Job No. 184041

September 7, 2022

Re: Response to:
Colorado Geological Survey Review Comments, dated June 29, 2022, and
El Paso County Planning and Community Development Comments, dated July 15, 2022.

RMG - Rocky Mountain Group prepared the *"Soil and Geology Study, Phase 1-4, Falcon Highlands"* (RMG Job No. 184041, last dated August 30, 2022) for the proposed development project comprising 380 single-family residential lots on approximately 126 acres east of the intersection of Highway 24 and Meridian Road in El Paso County, Colorado. The report was reviewed by personnel of the Colorado Geological Survey (CGS). The purpose of this letter is to provide our response to the CGS review comments. The responses and modifications noted herein have been incorporated into our amended report.

FIG No. 21

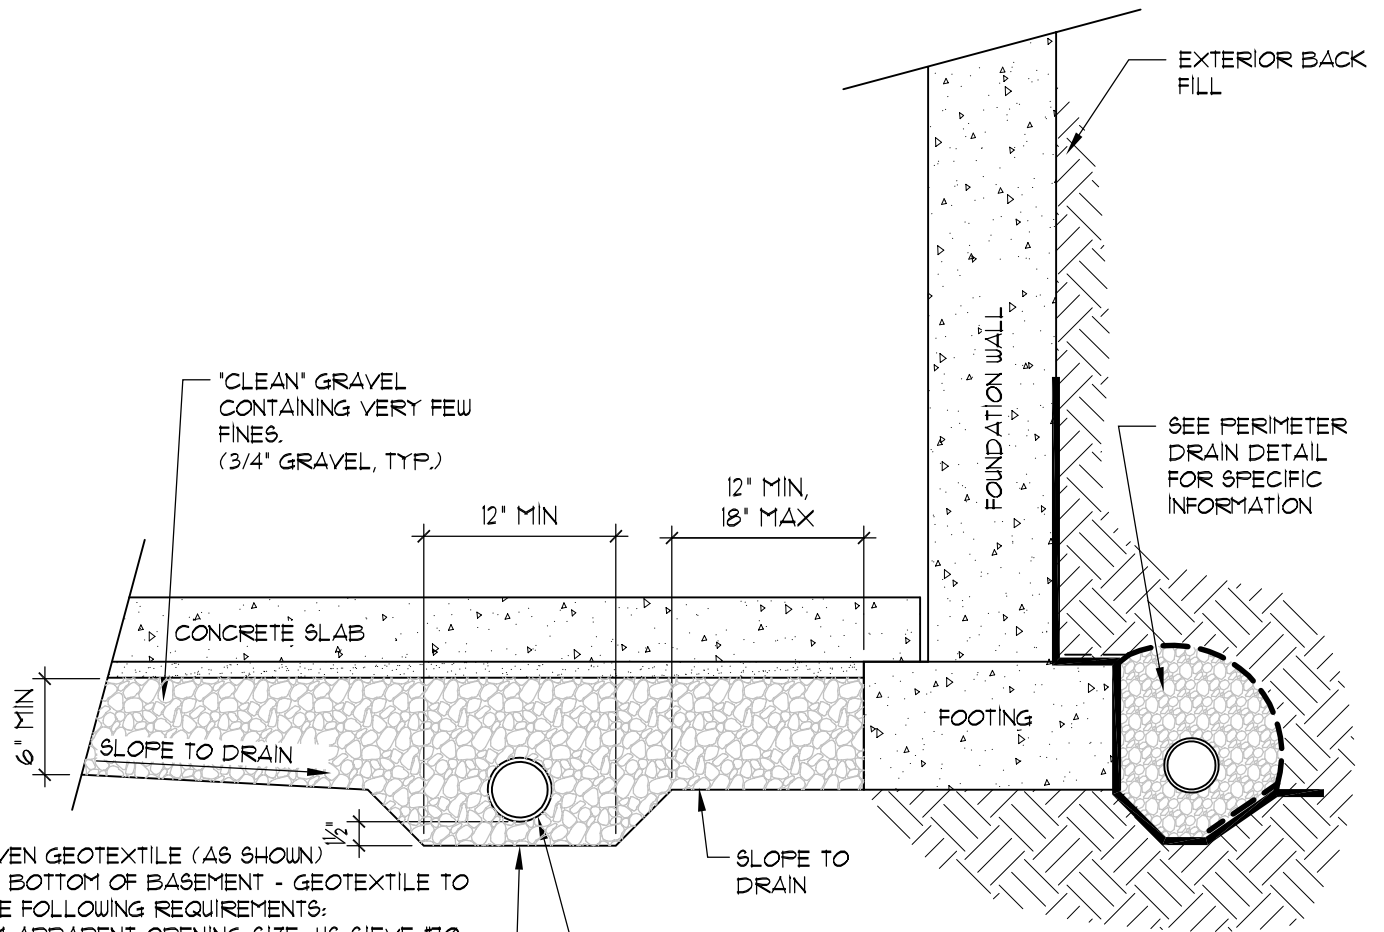
The Geology and Soils Note on the Development plan differs from the recommendations of RMG. The note states, "Exterior, perimeter foundation drains shall be installed around below-grade habitable or storage spaces." CGS recommends that this note be expanded to summarize RMG's recommendations on p.14 "In areas where basements are proposed, an underdrain placed at the bottom of sanitary sewer trenches within drive lanes may help reduce the impact of groundwater on basement suitability." And that "basement construction should be restricted except where one of the following conditions apply:
Underdrains are installed at the bottom of sanitary sewer trenches within drive lanes;
A year-long groundwater monitoring study has been undertaken, and the results indicate that groundwater is sufficiently deep to allow basement construction;
The proposed site grading will result in at least 14 feet of separation between the proposed ground surface and the groundwater elevation."

The Development Plan note has been revised and expanded per CGS's recommendation.

FIG No. 22

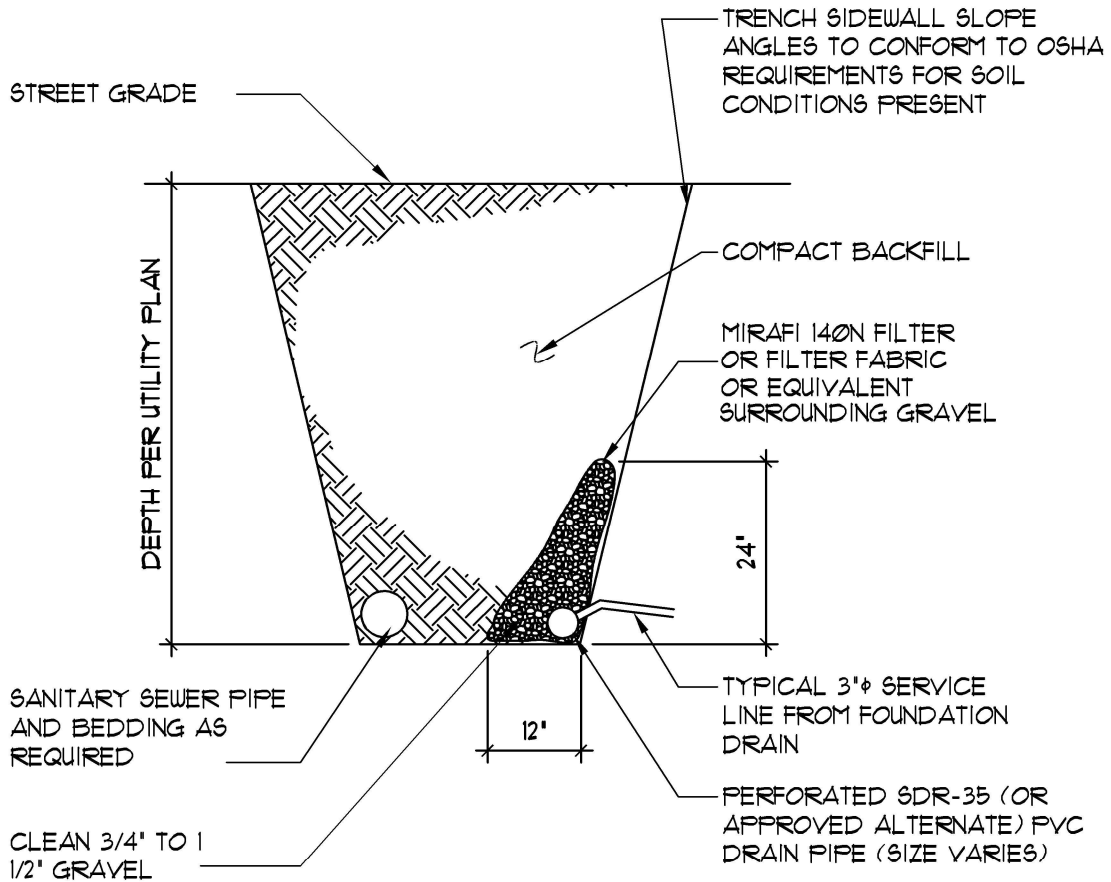
RMG states on p. 14, "If groundwater is encountered at the time of the site-specific subsurface soil investigations within 4 to 6 feet of the proposed basement slab elevation, an underslab drain would be considered in conjunction with the perimeter drain."

We agree with using an underslab drain should water be expected within 4 to 6 feet of the proposed basement slab elevation. However, site-specific subsurface soil investigations only provide a "snap-shot" of water levels. Groundwater measurements at the time of drilling, or even several weeks later, do not provide the necessary data to determine groundwater fluctuations. Discussion in the report should include the expected seasonal groundwater variation as part of the geologic description of the site. Monitoring groundwater levels through a complete spring-summer-fall-winter cycle remain the most reliable way to estimate from data the extent of seasonal fluctuations at a site.

Section 7.6 Ponding Water, Springs and Seasonal Groundwater within the Soils and Geology Study has been revised to include expanded discussions on seasonal groundwater variations.
